**Tallawong Station Precinct South
Stage 2 (SSD-10425) and Modification Application (SSD-9063-MOD-1)**

Attachment A

Status **RF11 for DPIE** Dwg No. **DA-720-020** Rev **05**

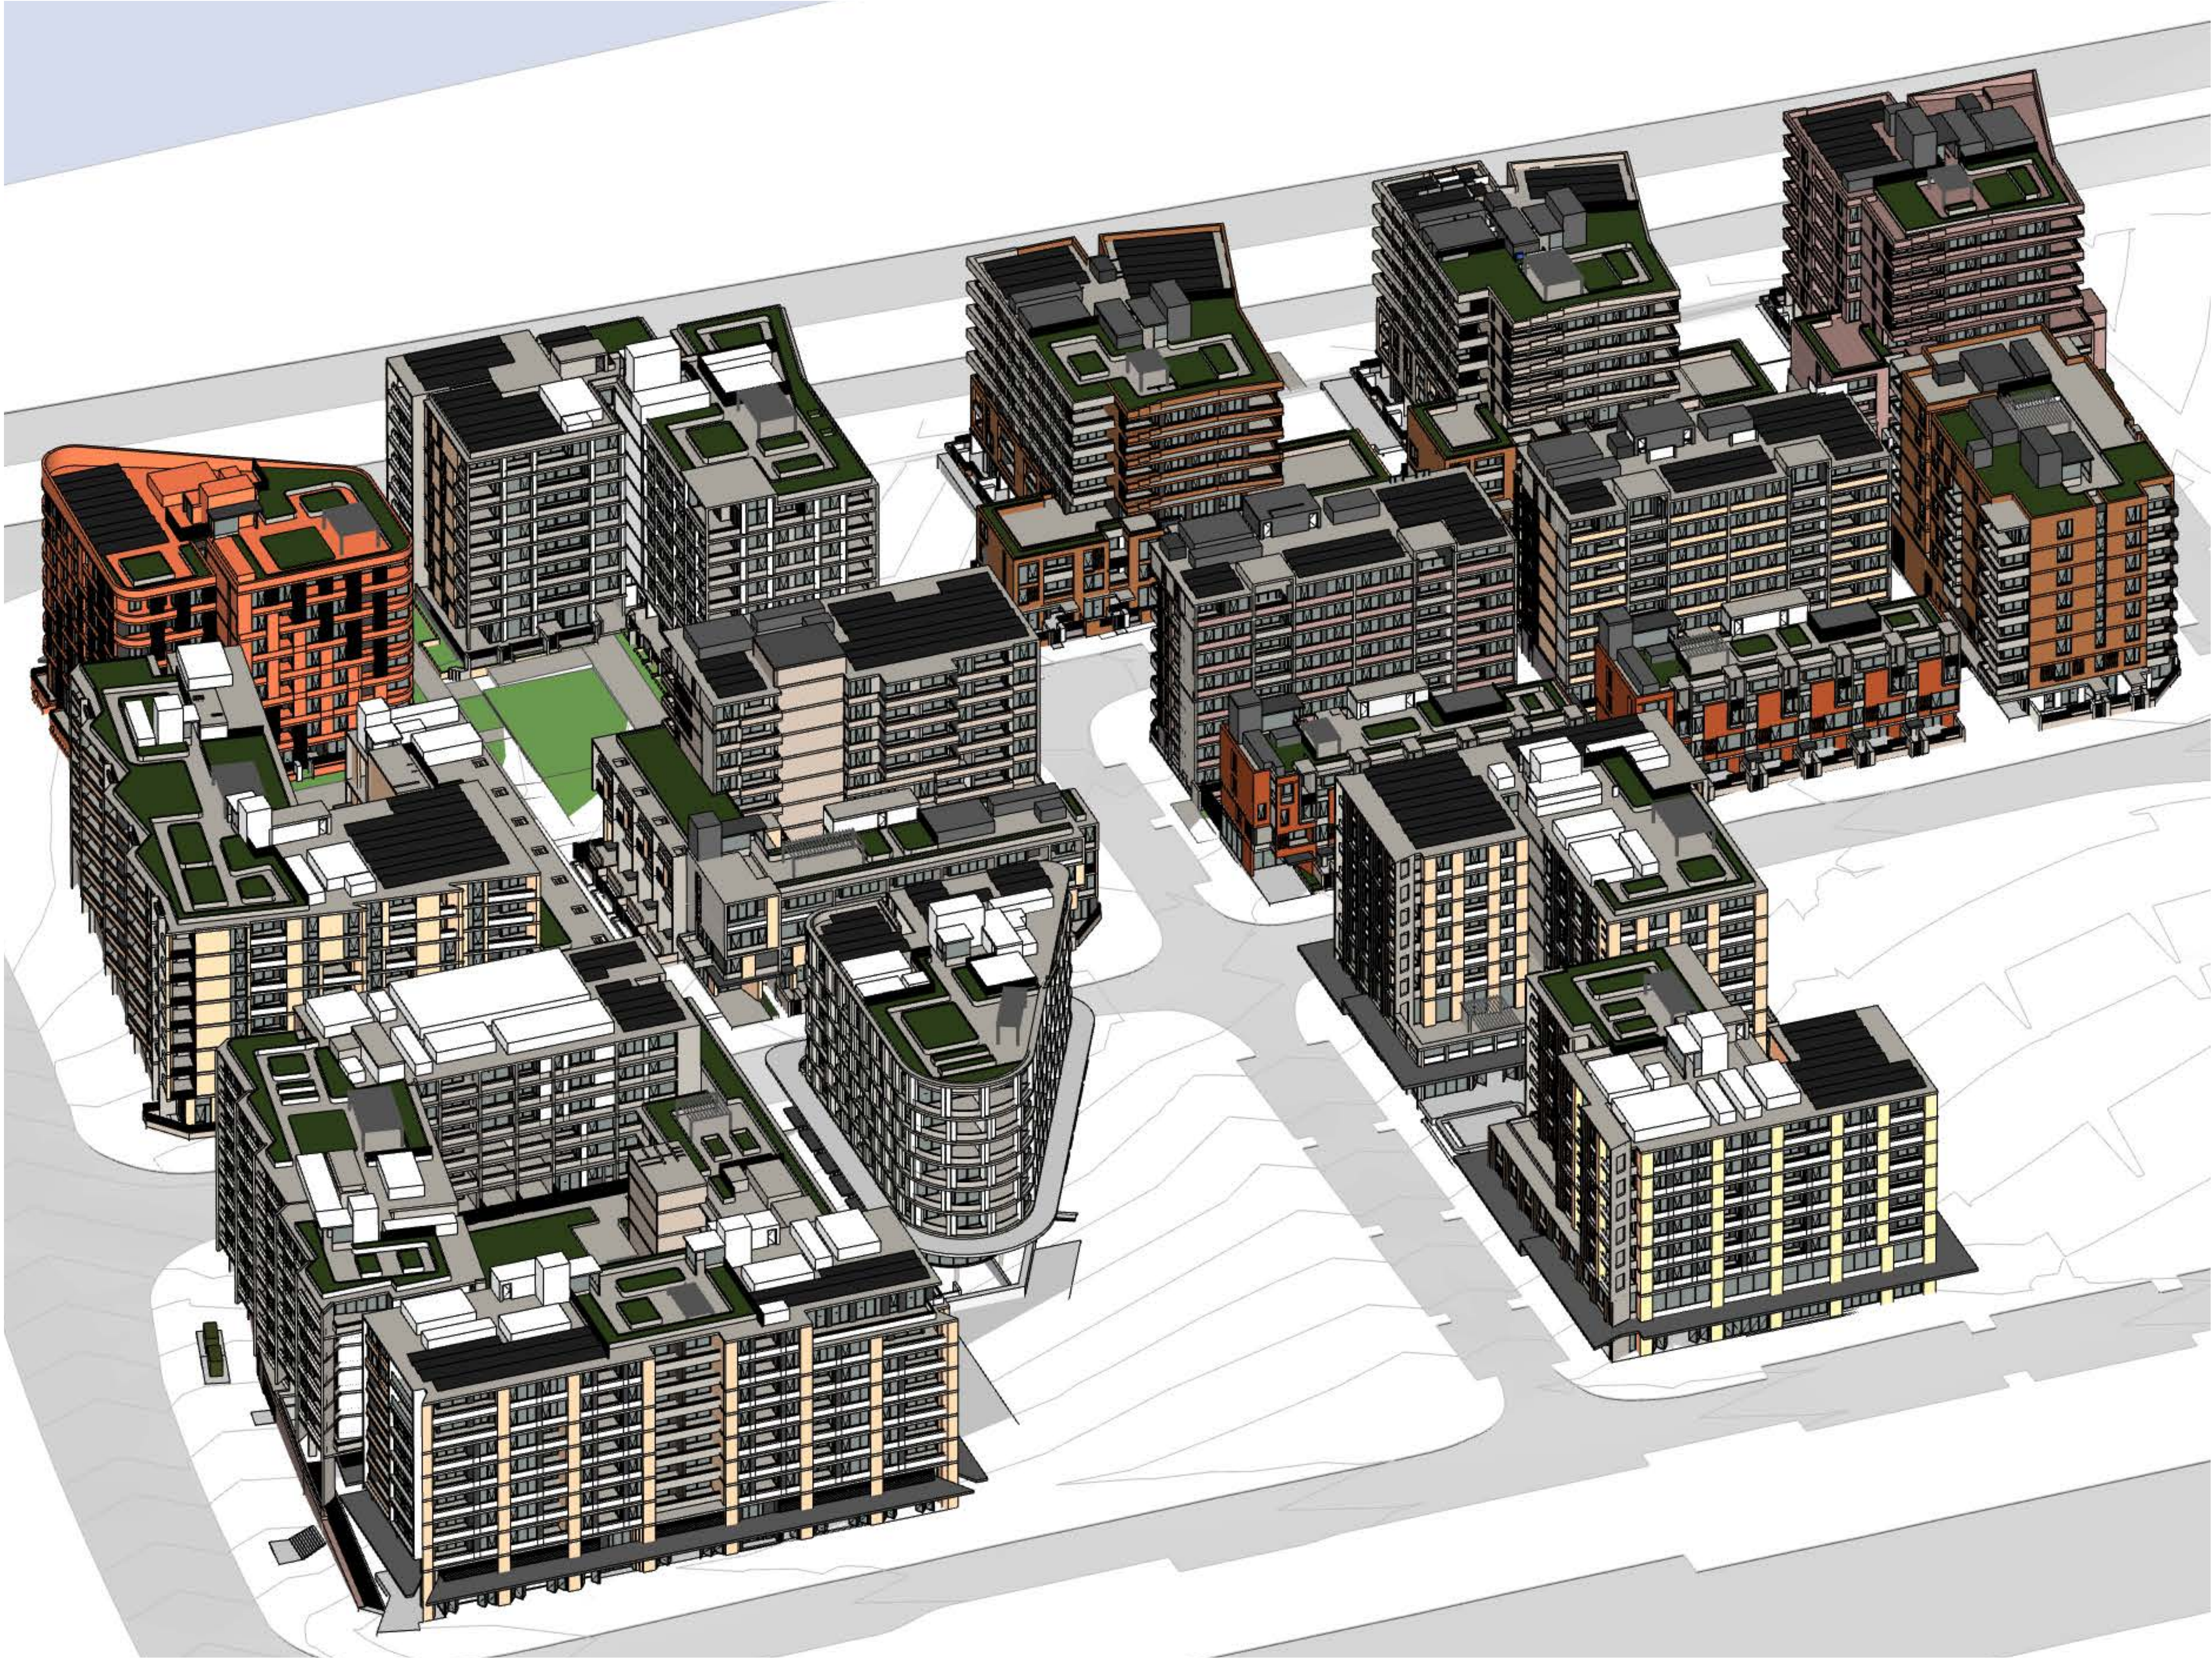
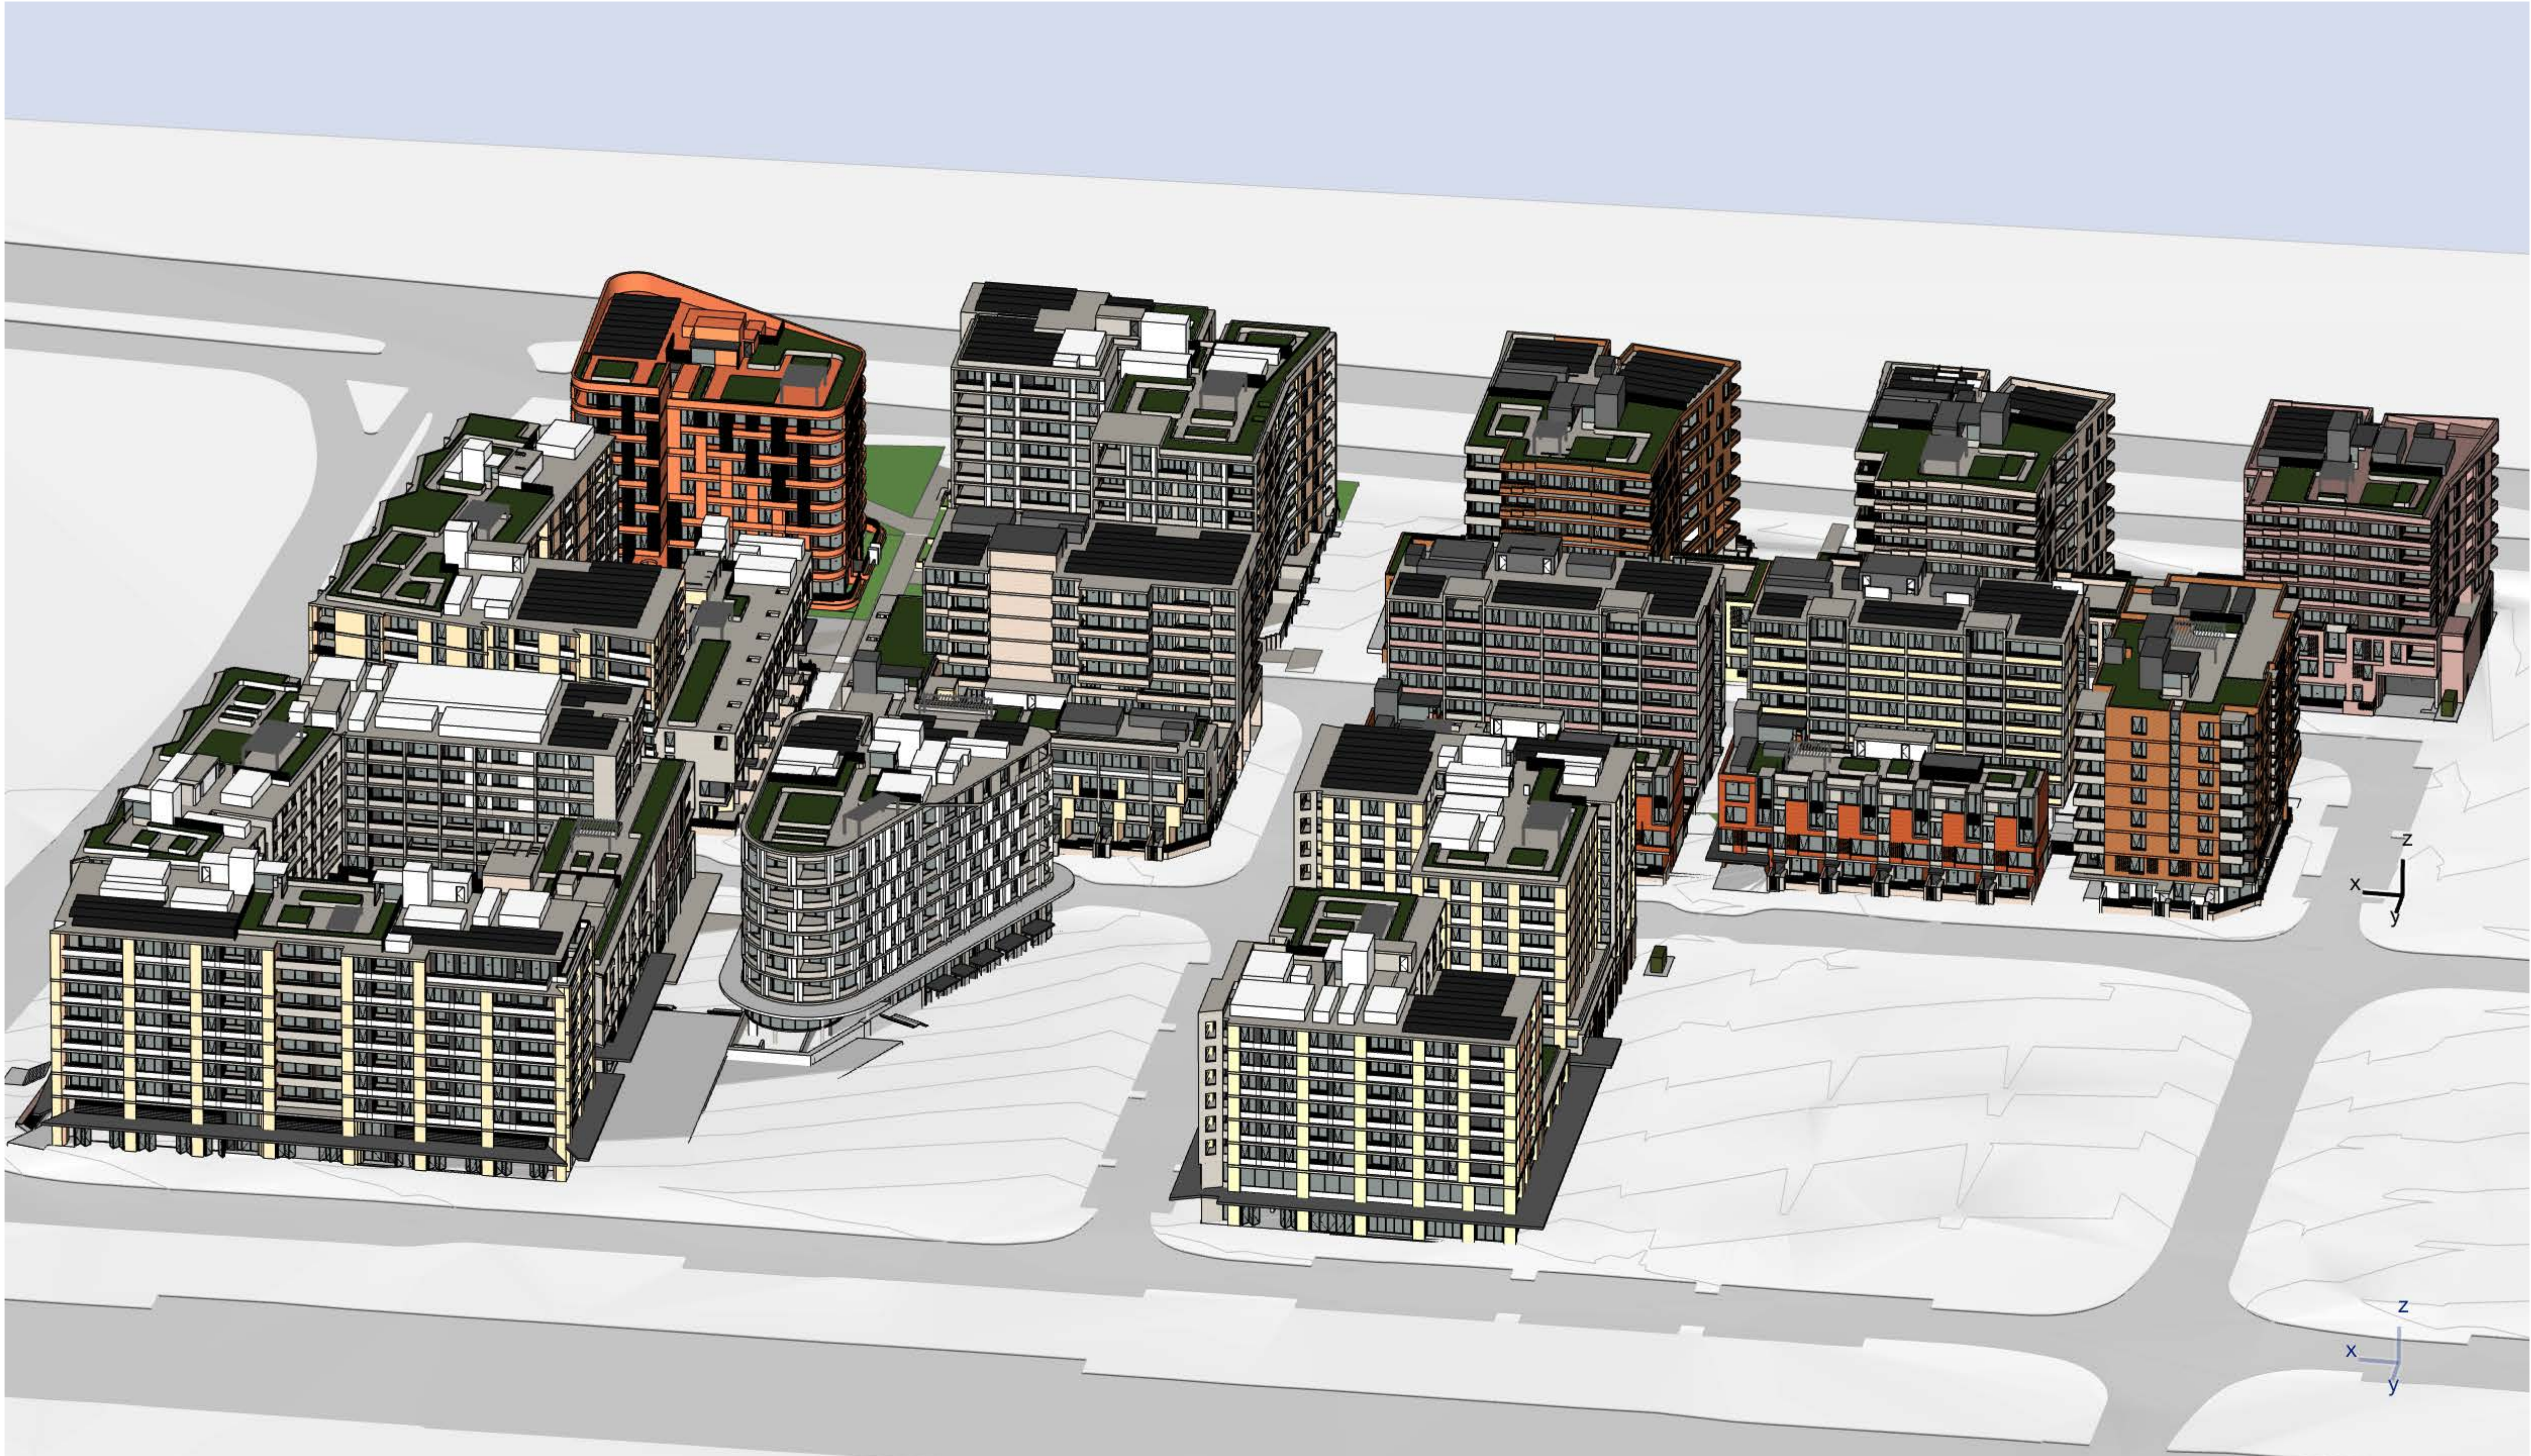
- i. Provide further information and analysis to demonstrate the proposal's compliance with the Apartment Design Guide (ADG), particularly how solar access and ventilation would be achieved for each of the proposed buildings. This must include (but not limited to):

- a. solar access diagrams to illustrate how solar access would be achieved for the proposed apartments
 - b. clarify how cross-ventilation and natural ventilation are achieved for apartments affected by rail and road noise.
